126-128 Danforth St - Permit 2017-00577 - replace front stairs & entry porch

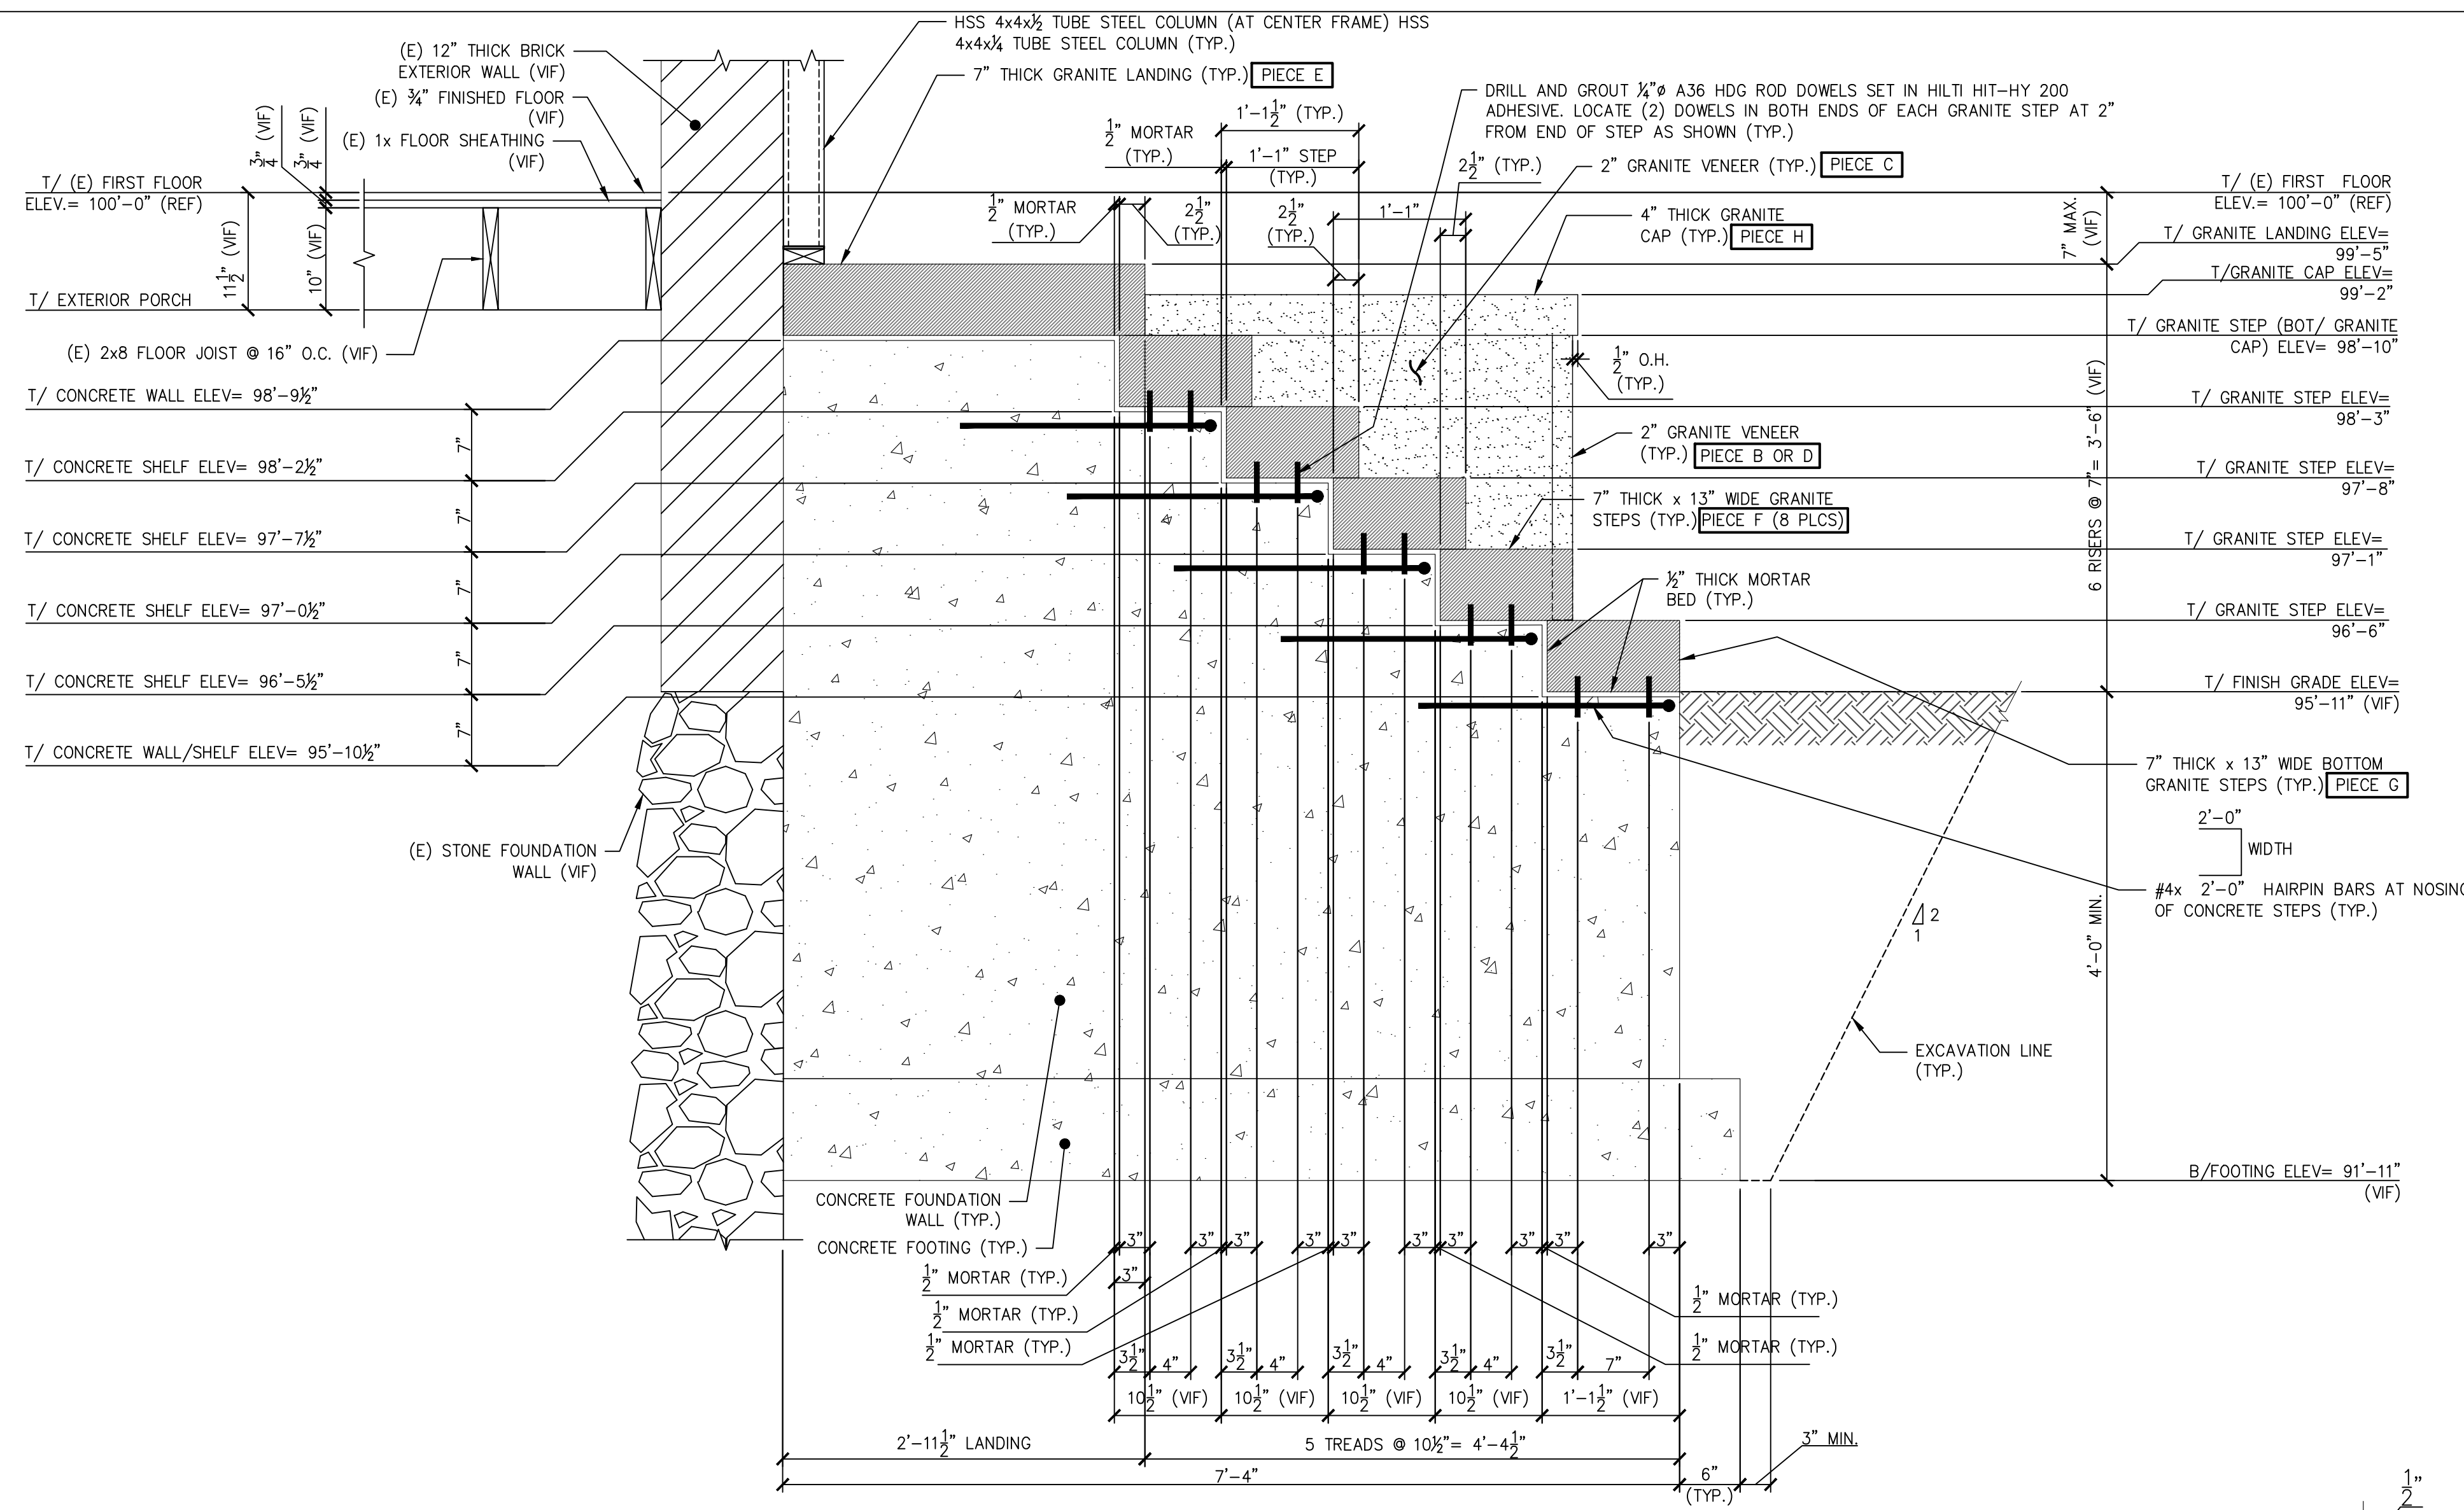
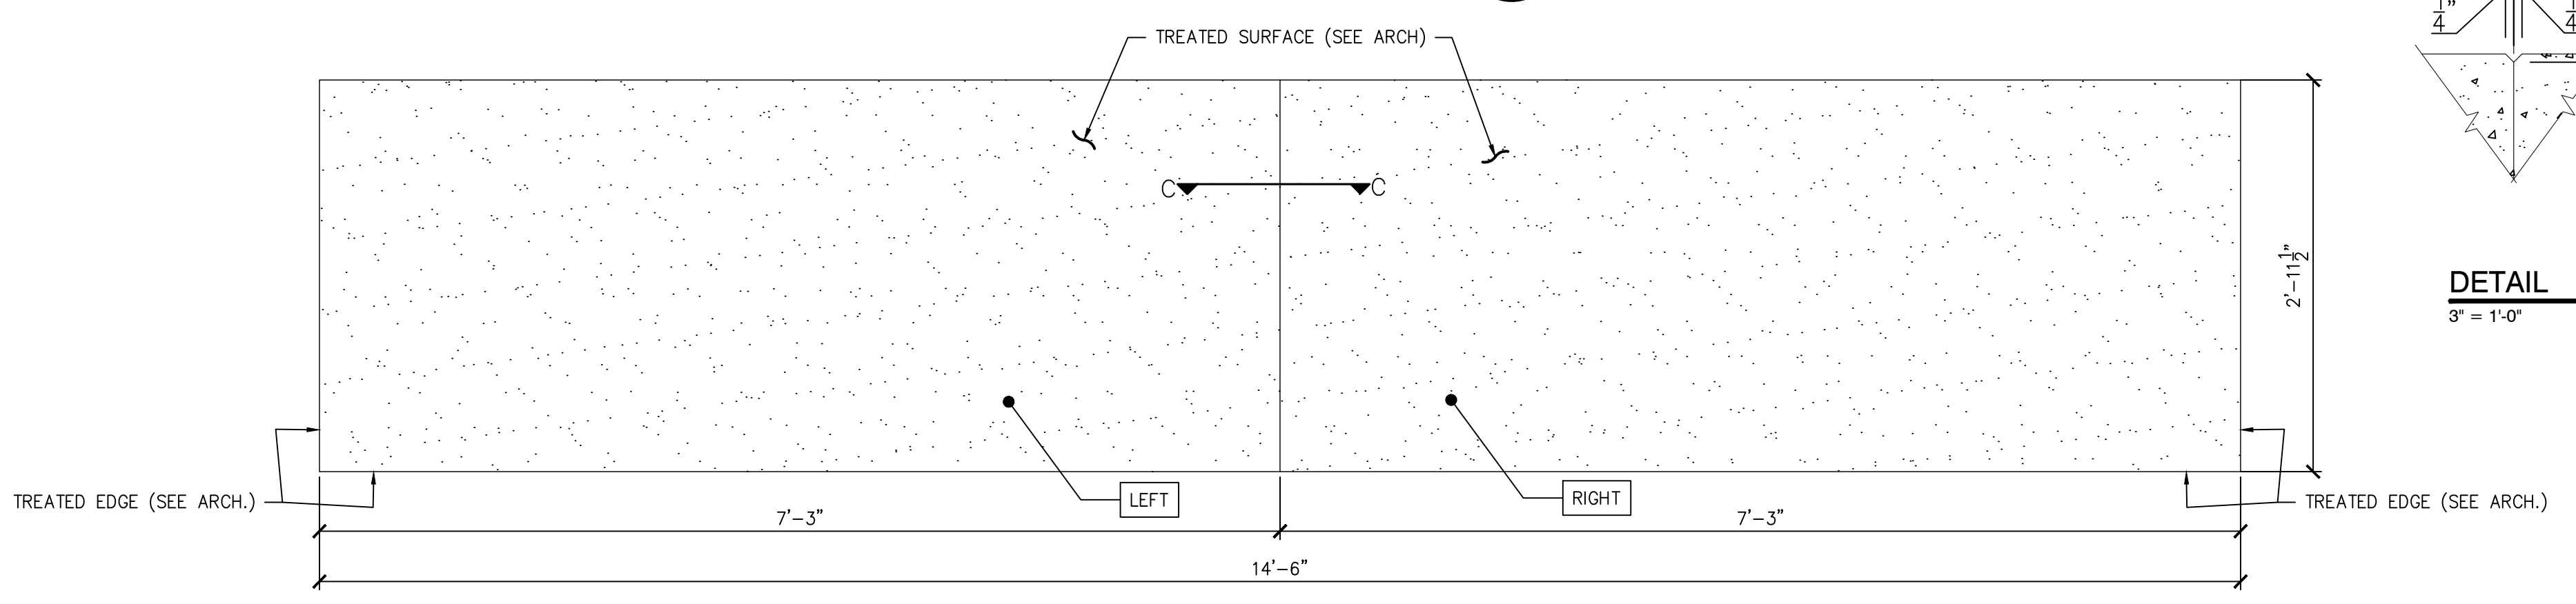
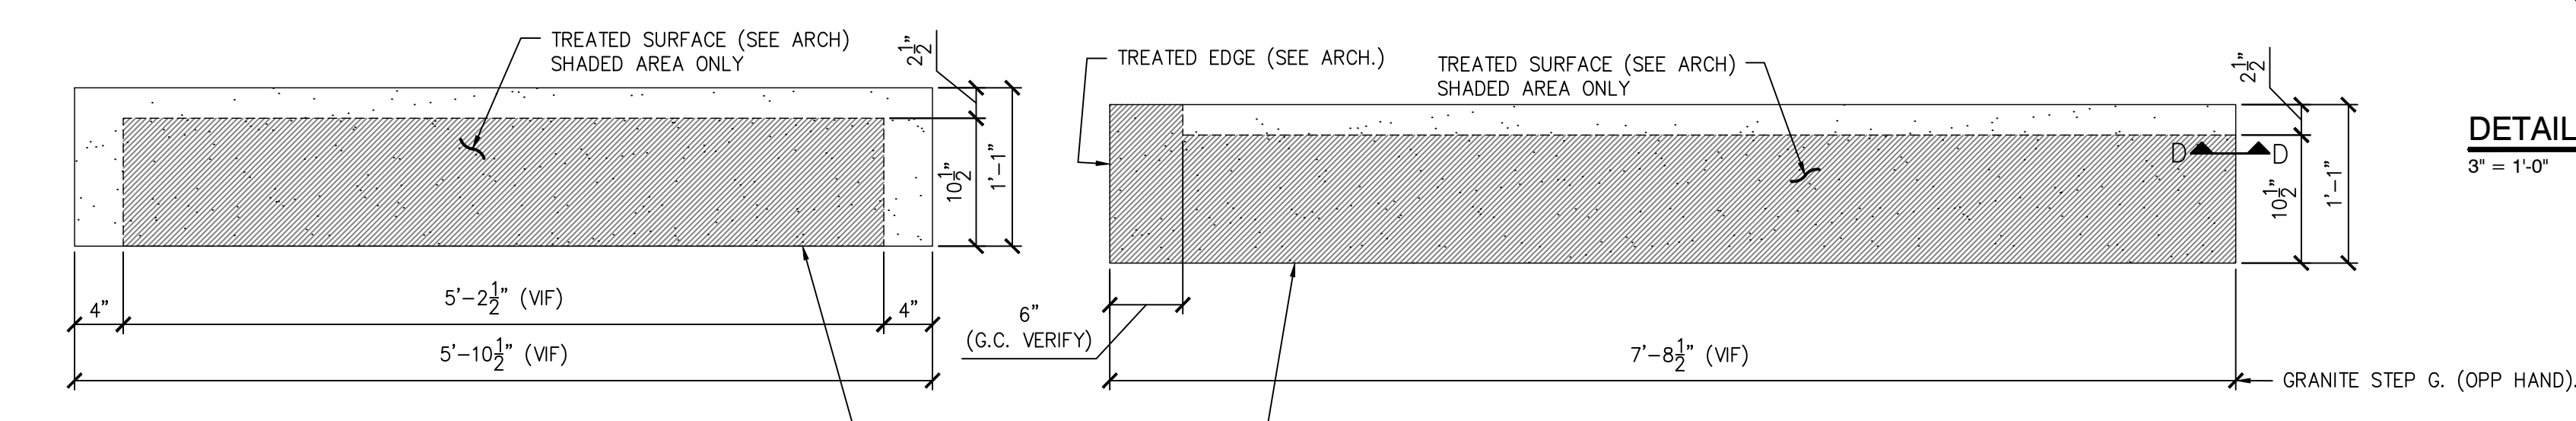
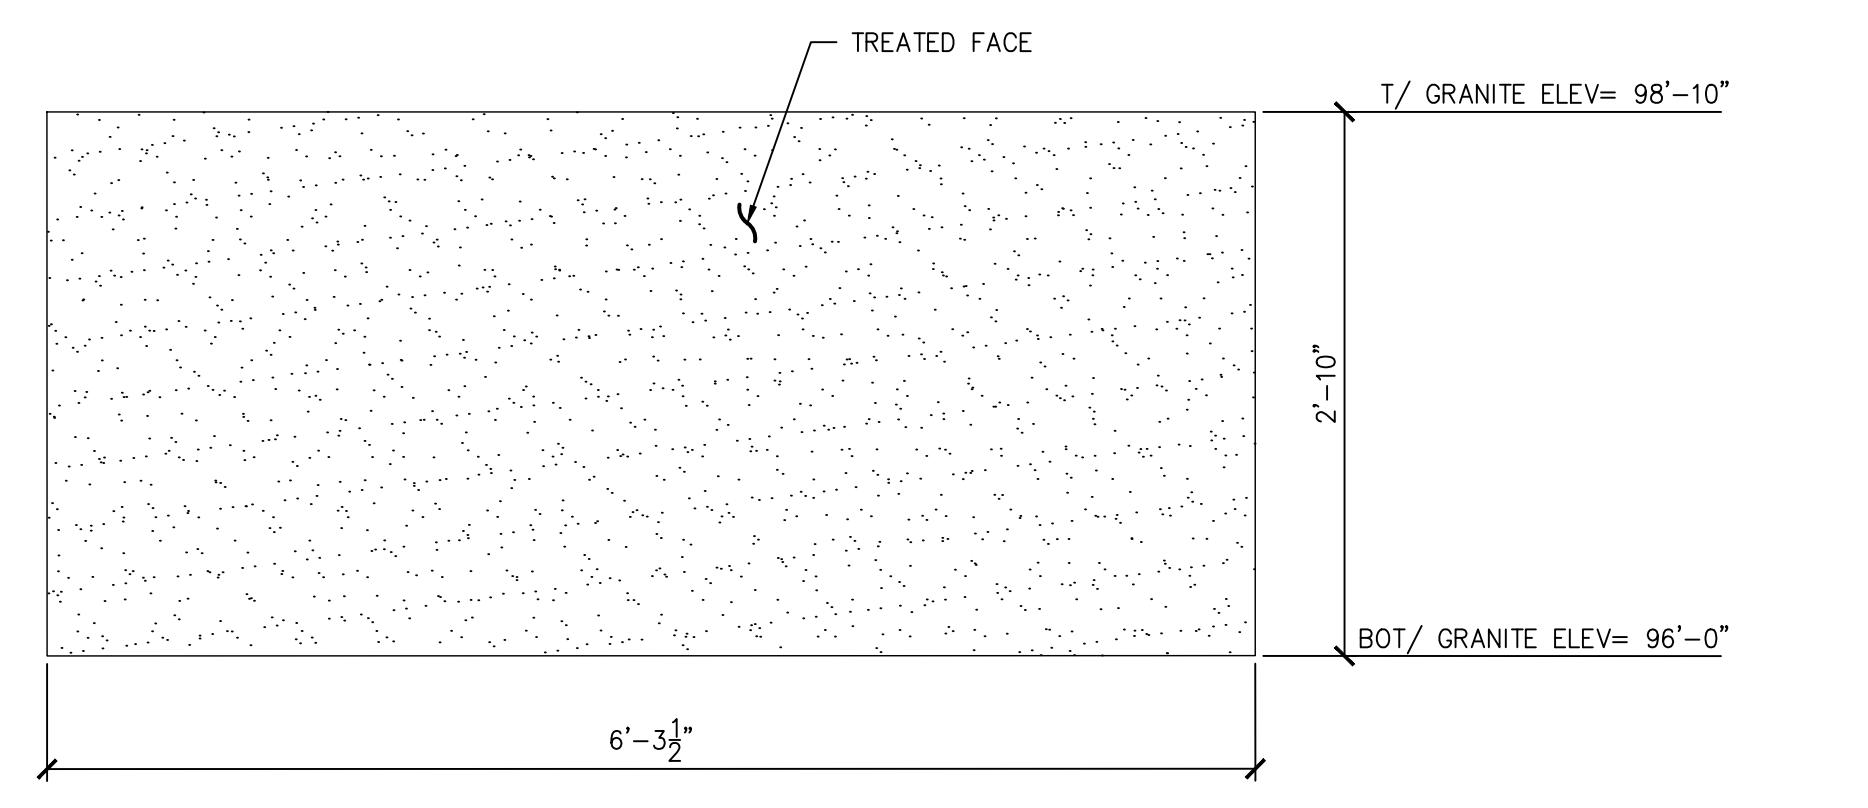
Yes these new stairs/ walls will be same footprint as the existing stairs and landing except for 6" of the new conc. footing (see Dwg S3)

which will be under the existing brick sidewalk beyond the end of the bottom granite riser.
